Dogger Bank South Offshore Wind Farm

Appendix B1 to the Natural England Deadline 1 Submission
Natural England's comments and updated advice on 10.38 Coastal Erosion Technical
Note [AS-116, Rev01]

Planning Inspectorate Reference EN010125

29th January 2025

Plate 2-1 Elevation difference between the 2008 and 2013 Lidar surveys across the intertidal area of the landfall

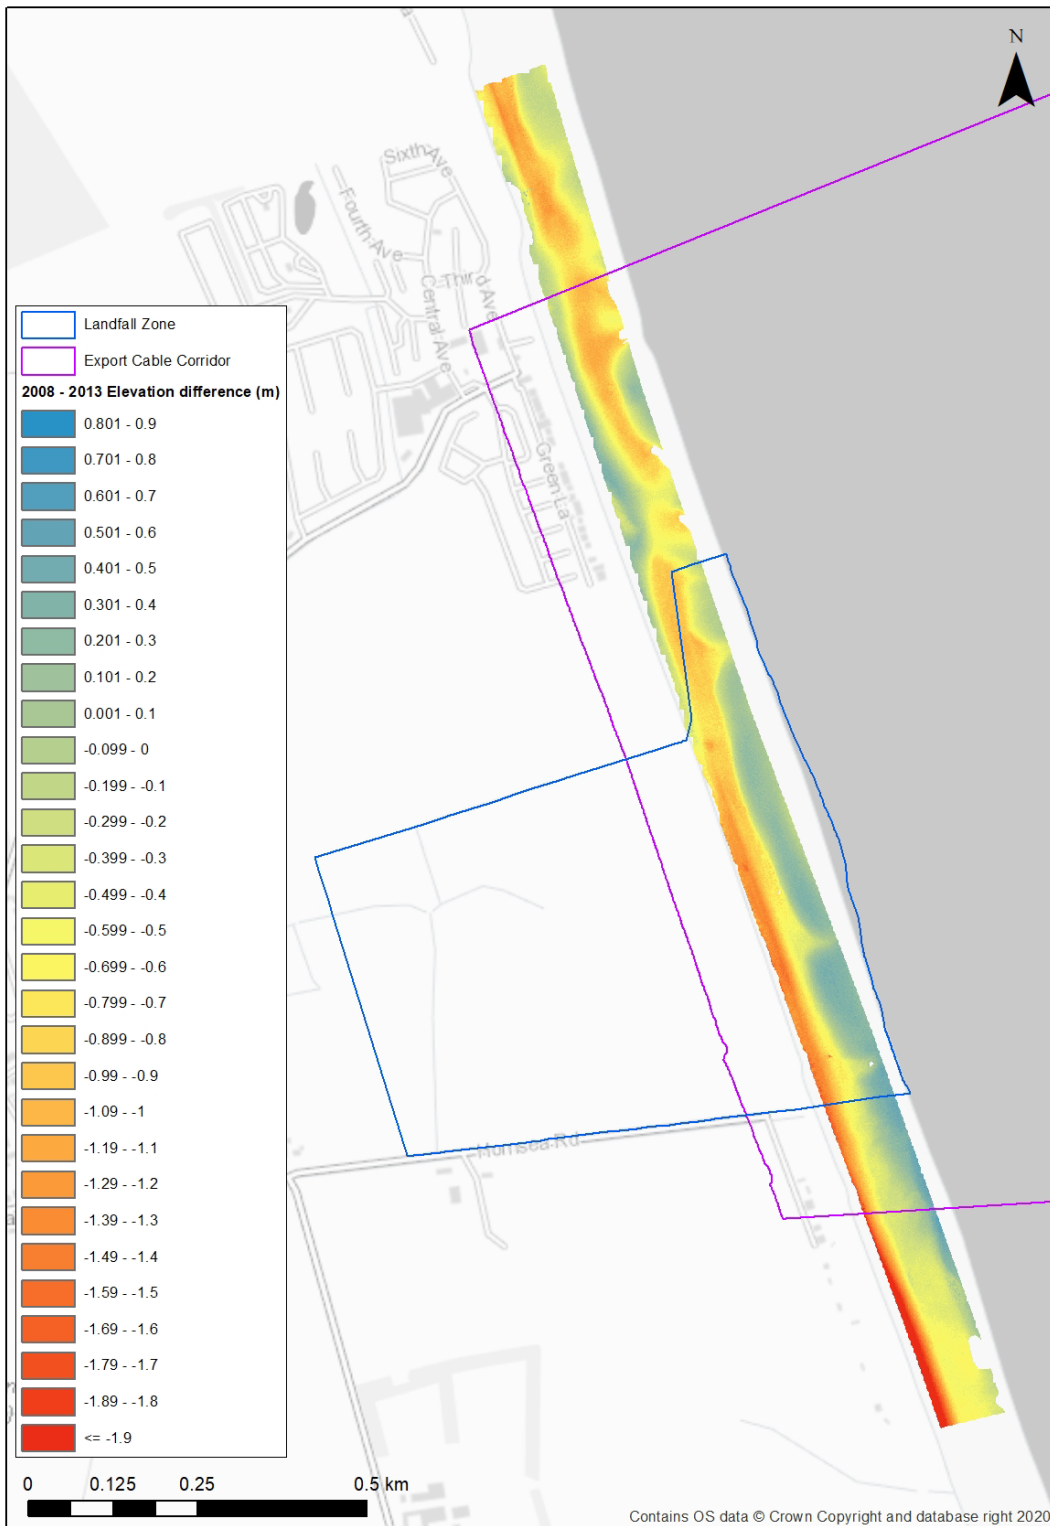
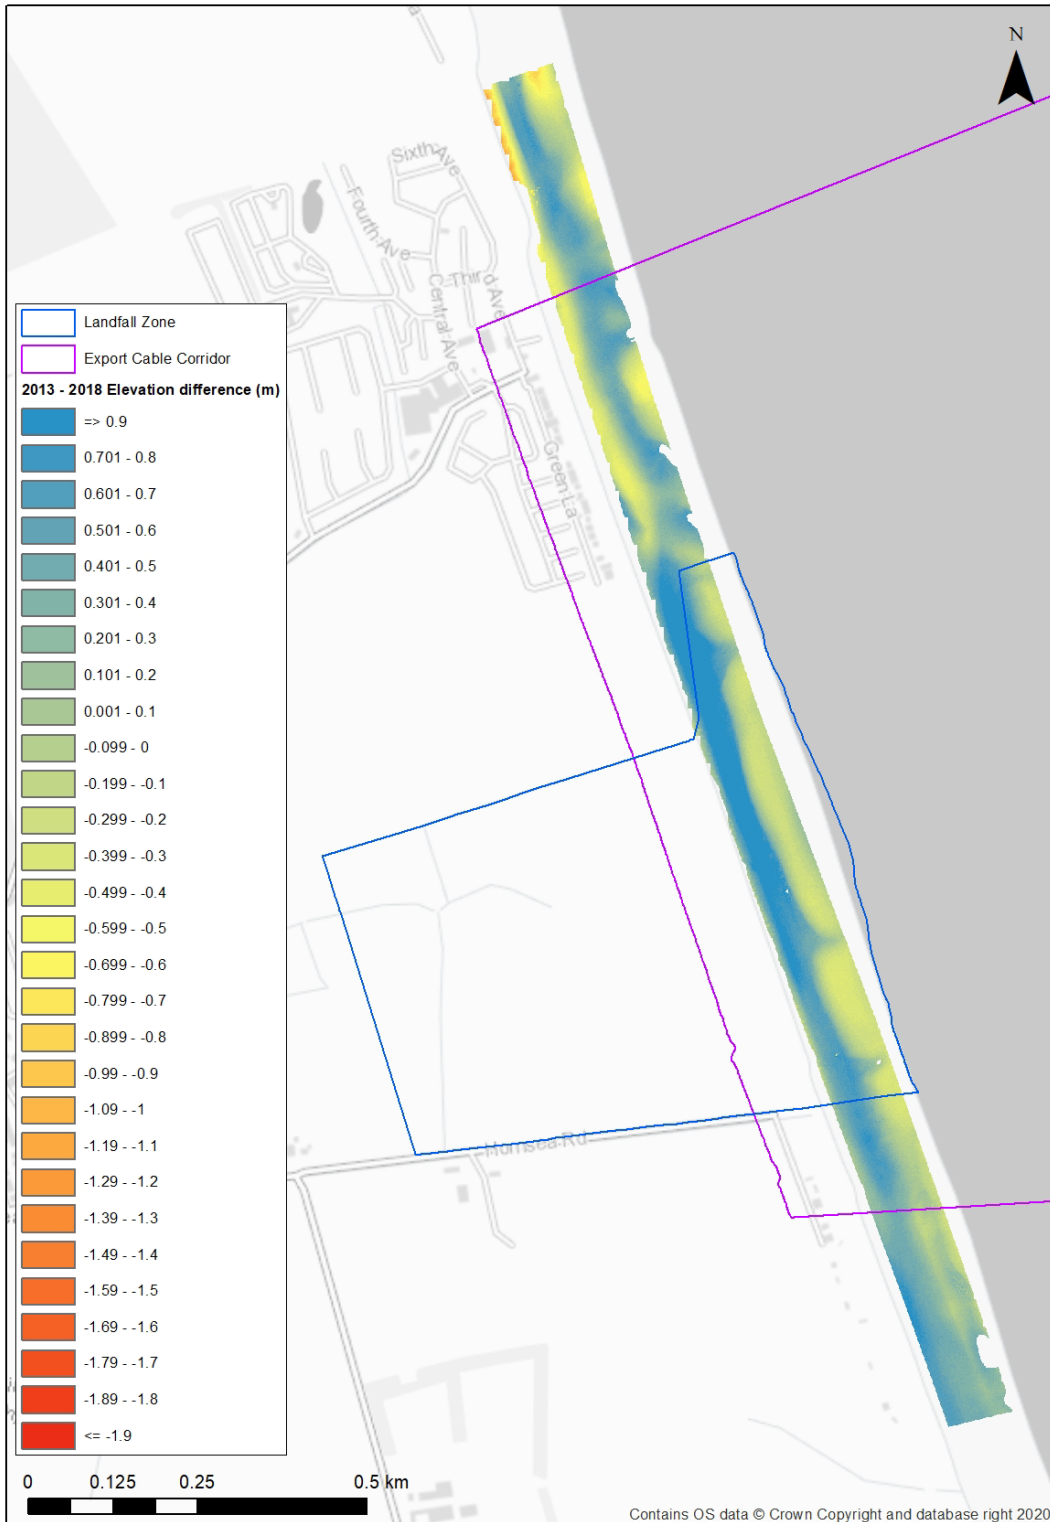
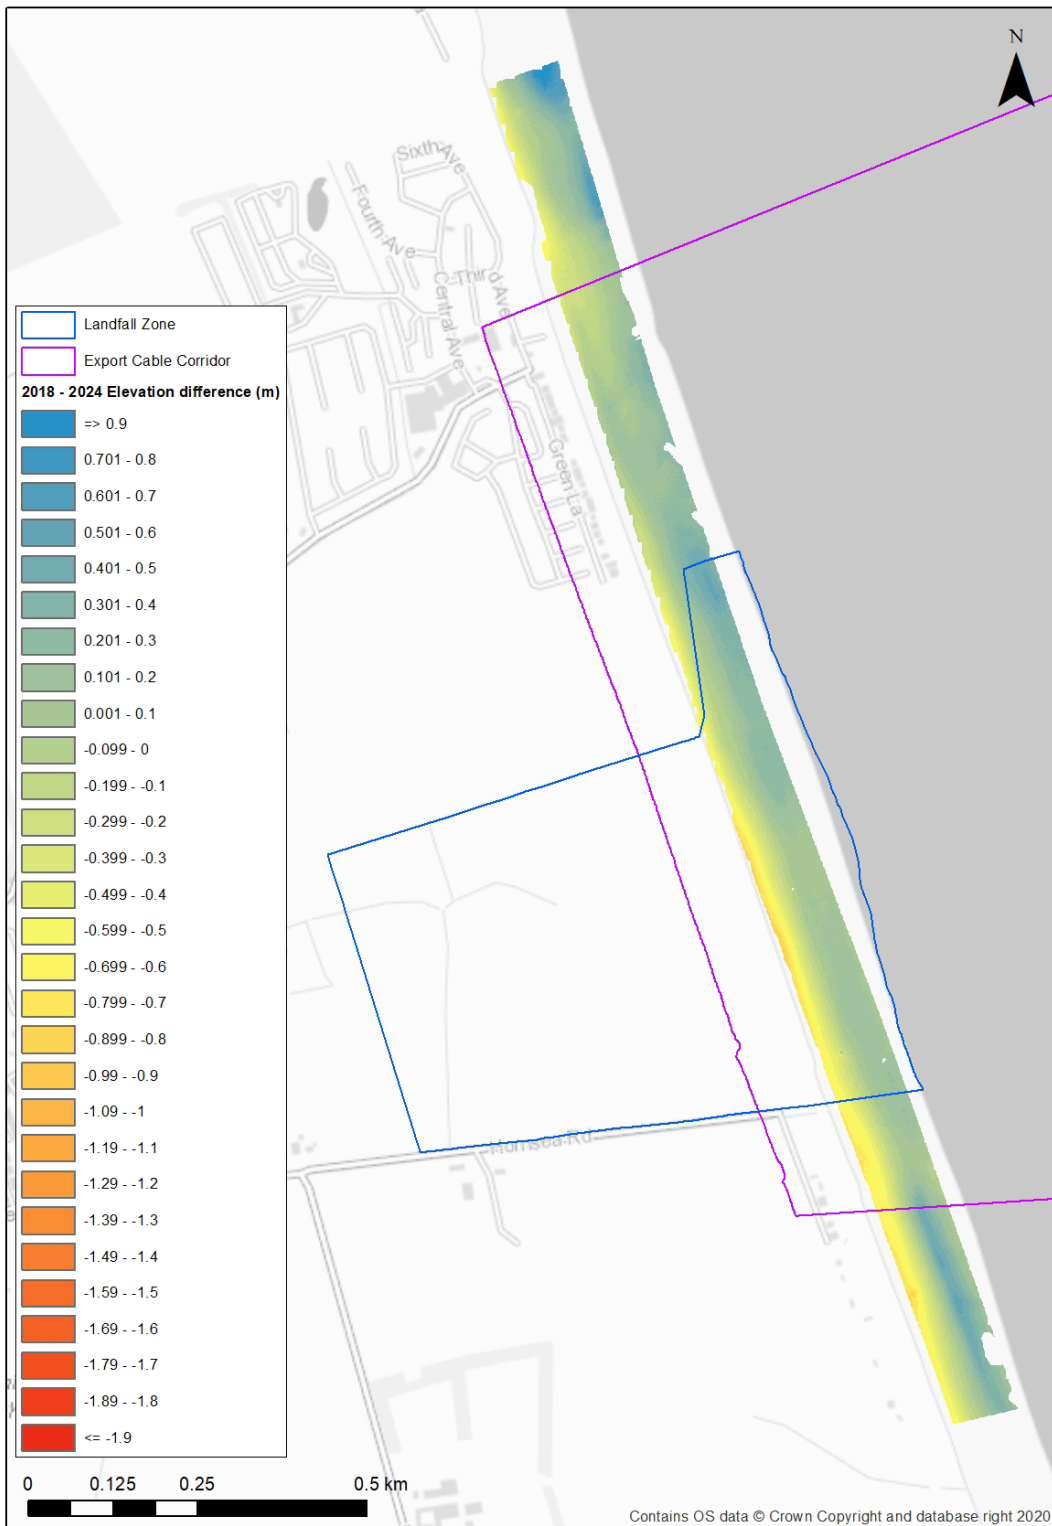
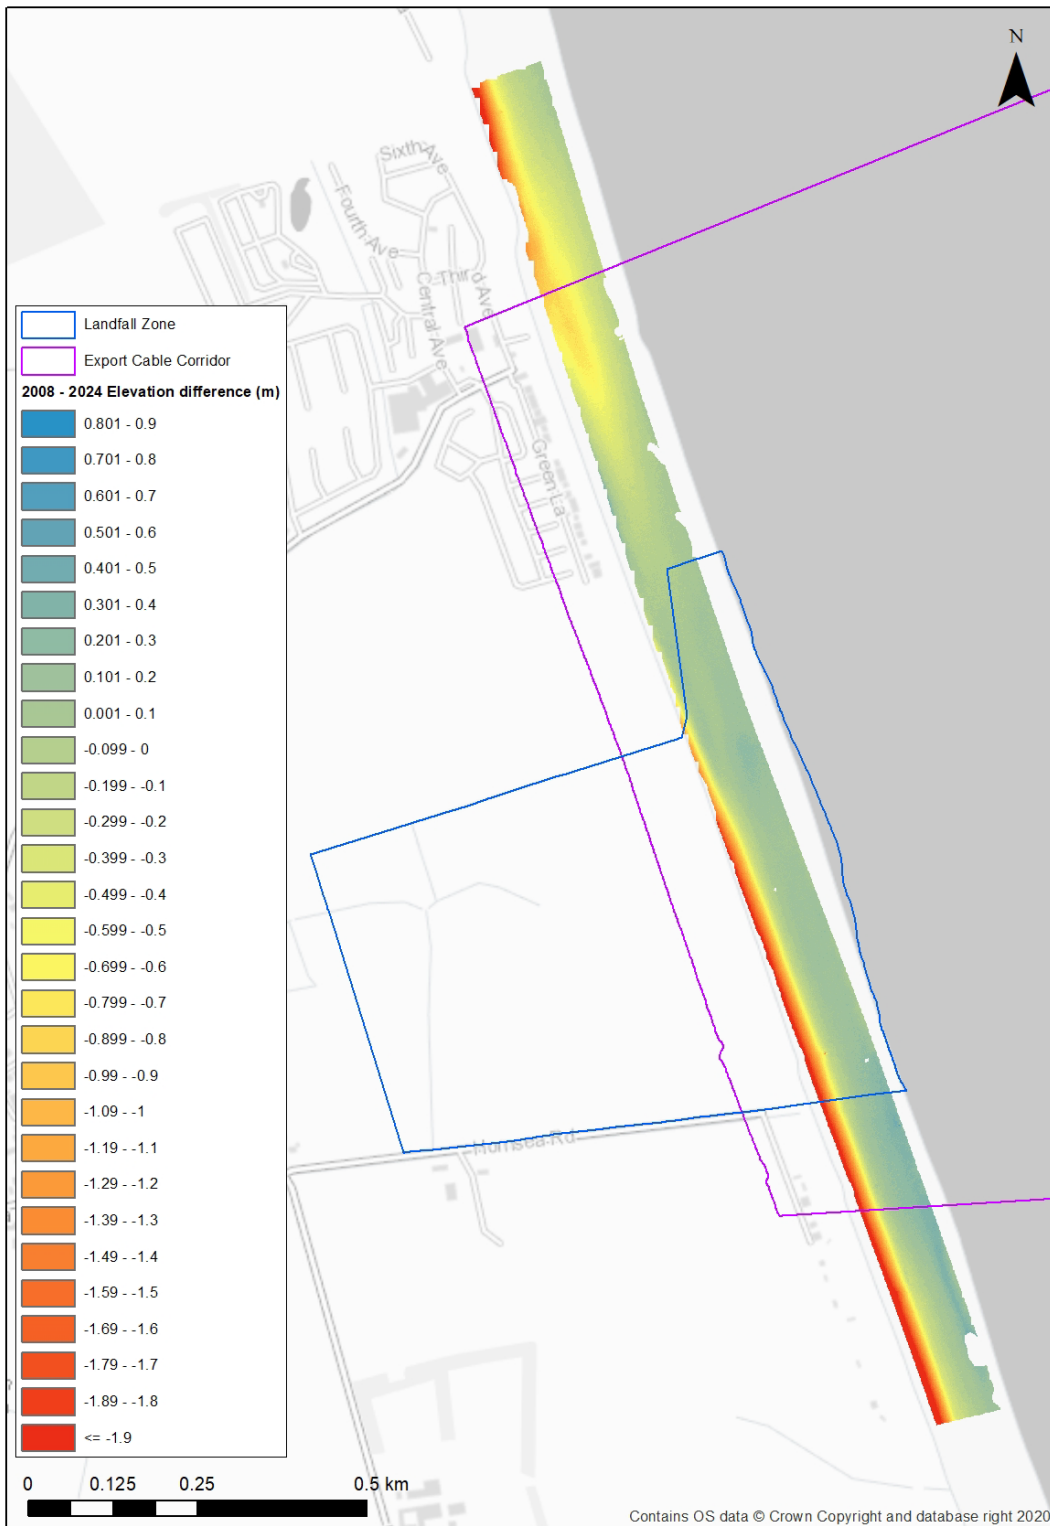
[RR-039, B20] Natural England raised that the beach elevation change data presented in Chapter 8 Marine Physical Environment [APP-080] from 2008 to 2015 was out of date and that there was insufficient information regarding beach elevation change and shore platform lowering.

The additional information presented in the above report [AS-116] provides further evidence around beach elevation and platform lowering. We consider that the new information is sufficient to demonstrate that the cables will be buried at a sufficient depth as to prevent exposure for the lifetime of the project.

Plate 2-5 Changes in relative sea level under the 50th percentile medium emissions scenario using a 2024 baseline

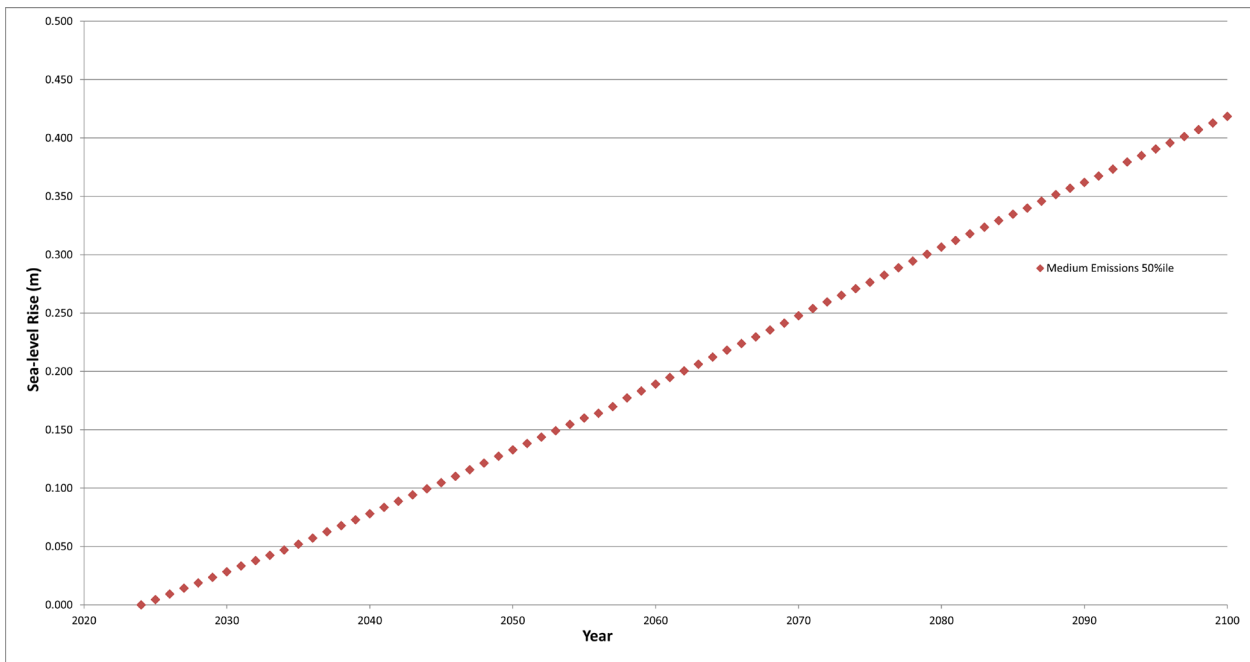
[RR-039, B23] Natural England highlighted that the use of the UKCP18 high emission scenario (RCP8.5) at the 50% confidence level was not consistent with the National Coastal Erosion Risk Mapping project (NCERM2), which uses the 70% and 95% confidence levels.

Whilst new data has been presented, the Applicant is still using the 50% confidence level rather than a worst-case scenario (95%). We consider that sea level rise data from the 95th percentile UKCP18 Representative Concentration Pathway (RCP) 8.5 climate projection is publicly available and should be able to be applied to the local data that the Applicant has received from East Riding of Yorkshire Council. However, we also note that the Applicant has committed in paragraph 14 of AS-116 that *“Should NCERM2 be made available (estimated to be in 2025) whilst the DBS DCO Examination is ongoing the Applicants will be happy to present erosion predictions around the proposed the landfall as requested”*. We welcome this commitment and understand that NCERM2 data is going to be publicly released on the 28th January 2025, so should be available to inform updated landfall cable installation assessments during this examination.
